Recommendation Report for Planning Permission

REF NO: LU/237/15/PL

LOCATION: The White Hart Public House
32 Surrey Street
Littlehampton

PROPOSAL: Removal of old front porch & installation of new front porch, replacement of glazing to 2 No. ground floor front bay windows, 5 No. first floor front Georgian sash windows & 2 No. second floor front dormer windows & installation of former railings to forecourt perimeter. This application affects the character & appearance of the Littlehampton River Road Conservation Area. (Resubmission following LU/306/14/PL.)

PROPOSED SIDE (NORTH) ELEVATION

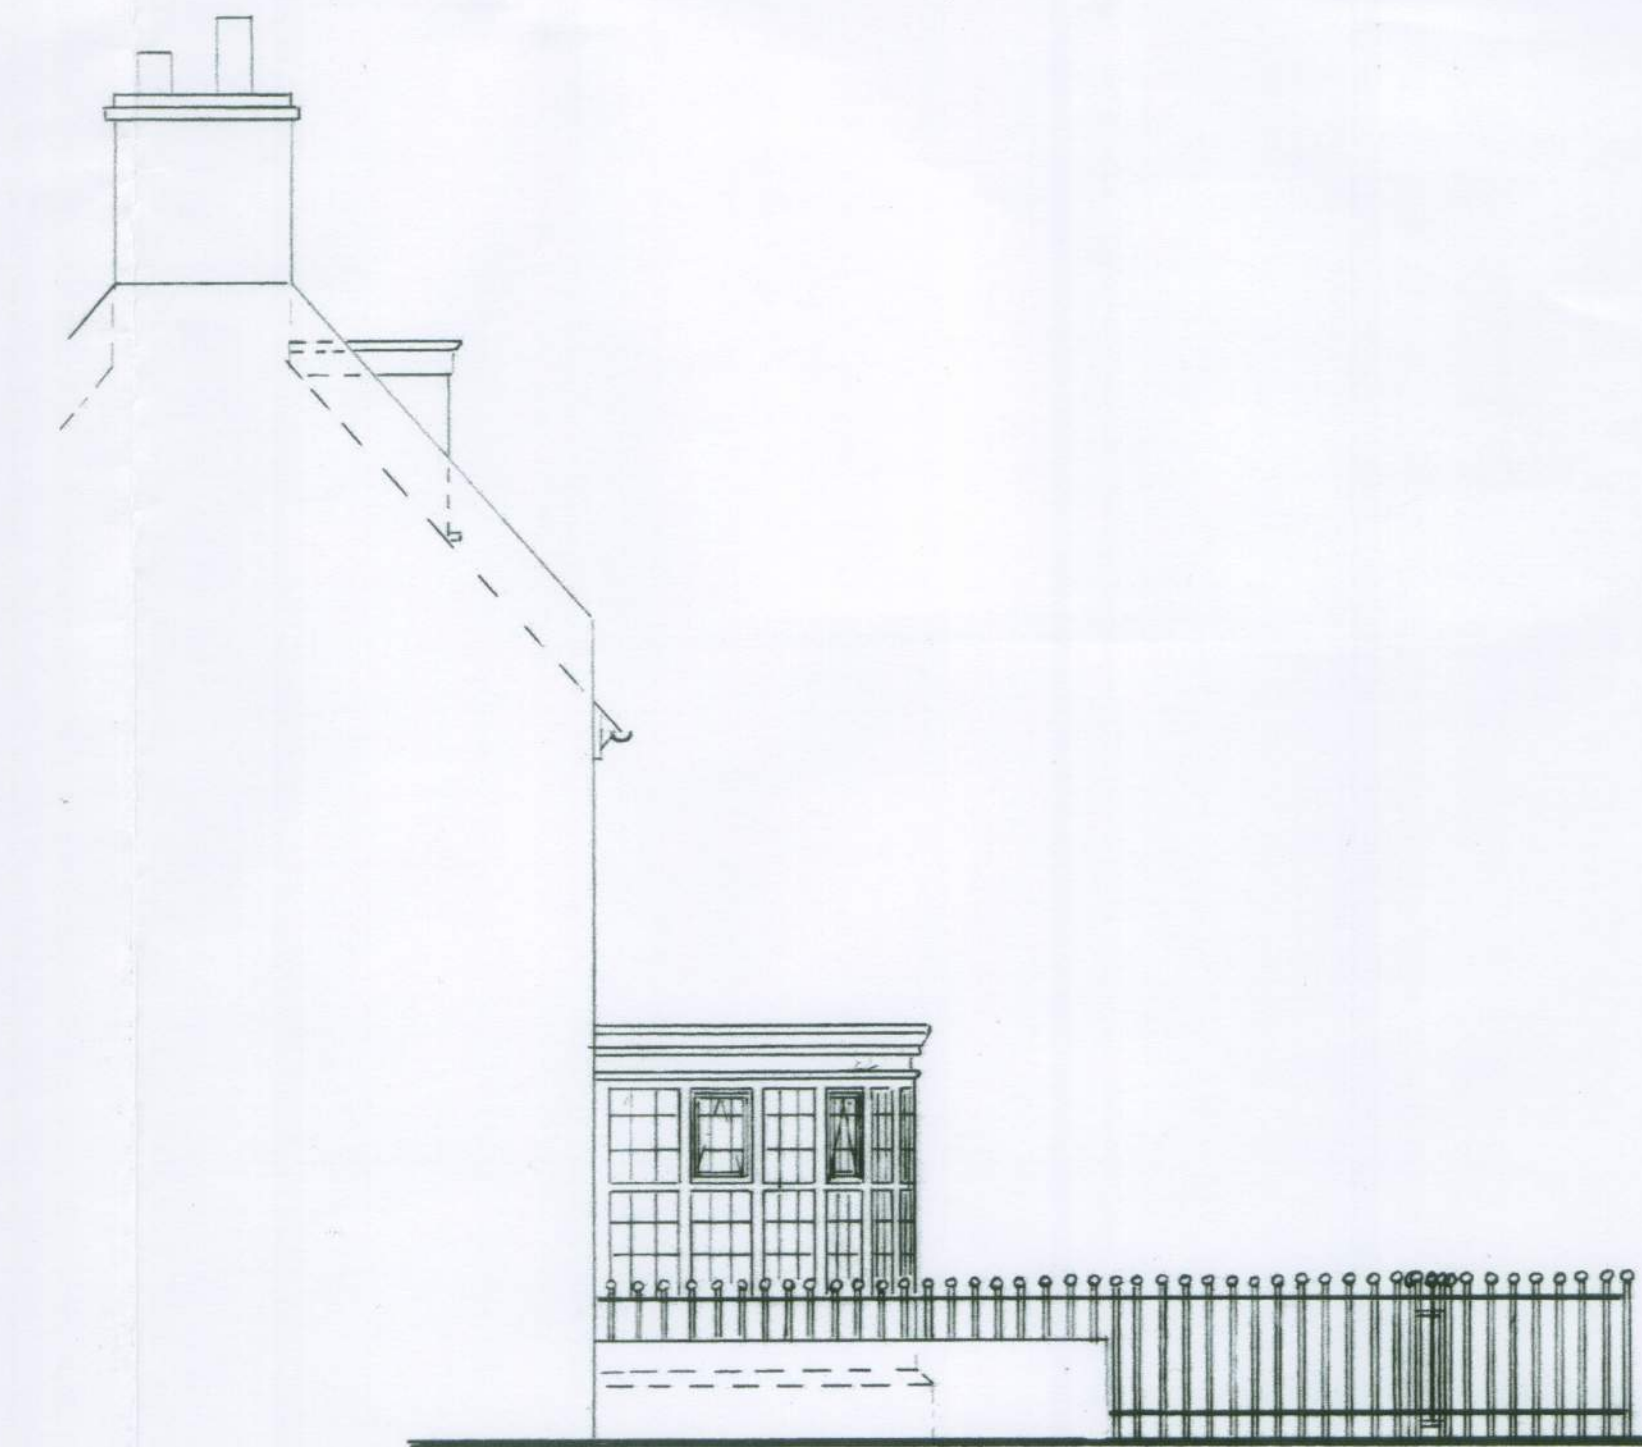
Conservation Area Advisory Committee - Windows should be refurbished and not replaced, repairing as much of the original timber and glass as possible. Comments re porch would like more detailed plans of porch to enable further comments to be made. Suggest an alternative approach would be to have an internal lobby and remove the existing porch with perhaps a small canopy.

Comments on railings - Objection- overpowering and out of keeping. Suggest sides only

This proposal also has three components. The replacement windows now proposed would match the existing in style, materials and design and there would therefore be no adverse impact on the appearance of the building in terms of its impact on visual amenity and the character of the area. However the application for Listed Building Consent has been refused in relation to the replacement windows in that their replacement, rather than repair, would adversely affect the historic fabric and character of the listed building.

The proposed changes to the porch would increase its size, but would centralise the appearance of the structure on the front elevation. The design of the porch has been amended and is now more in keeping with the appearance of the Listed Building and the appearance of the Conservation Area. It would be of limited dimensions and would not dominate the elevation. This element of the proposal would therefore also be acceptable in terms of its impact on the visual amenities of the locality and character of the area.

However, the railings are little altered from the previous refusal and remain unacceptable. The installation of railings to the forecourt area of the listed building would create a prominent and obtrusive means of enclosure in the street scene and adversely affect the open setting of the building. The extent of the area would not replicate that which historically existed at the site and would look out of place in this open area of street frontage. The railings would heighten the appearance of the building in the street scene and visually segregate it from its setting. Whilst

some form of enclosure may be acceptable the 13.5m length proposed would be overly dominant and would detract from the character and appearance of the Conservation Area where it would be viewed as an alien feature which would not preserve or enhance its historic setting.

- 1 By reason of the design, extent and position of the proposed railings they would damage the setting of a Grade 2 Listed Building and detract from the character and appearance of the Conservation Area by forming a prominent and obtrusive feature in the street scene in conflict with policies AREA2 and GEN7 of the Arun District Local Plan and with the National Planning Policy Framework.
- 2 **INFORMATIVE:** Statement pursuant to Article 35 of the Town and Country Planning (Development Management Procedure)(England) Order 2015. The Local Planning Authority has acted positively and proactively in determining this application by identifying
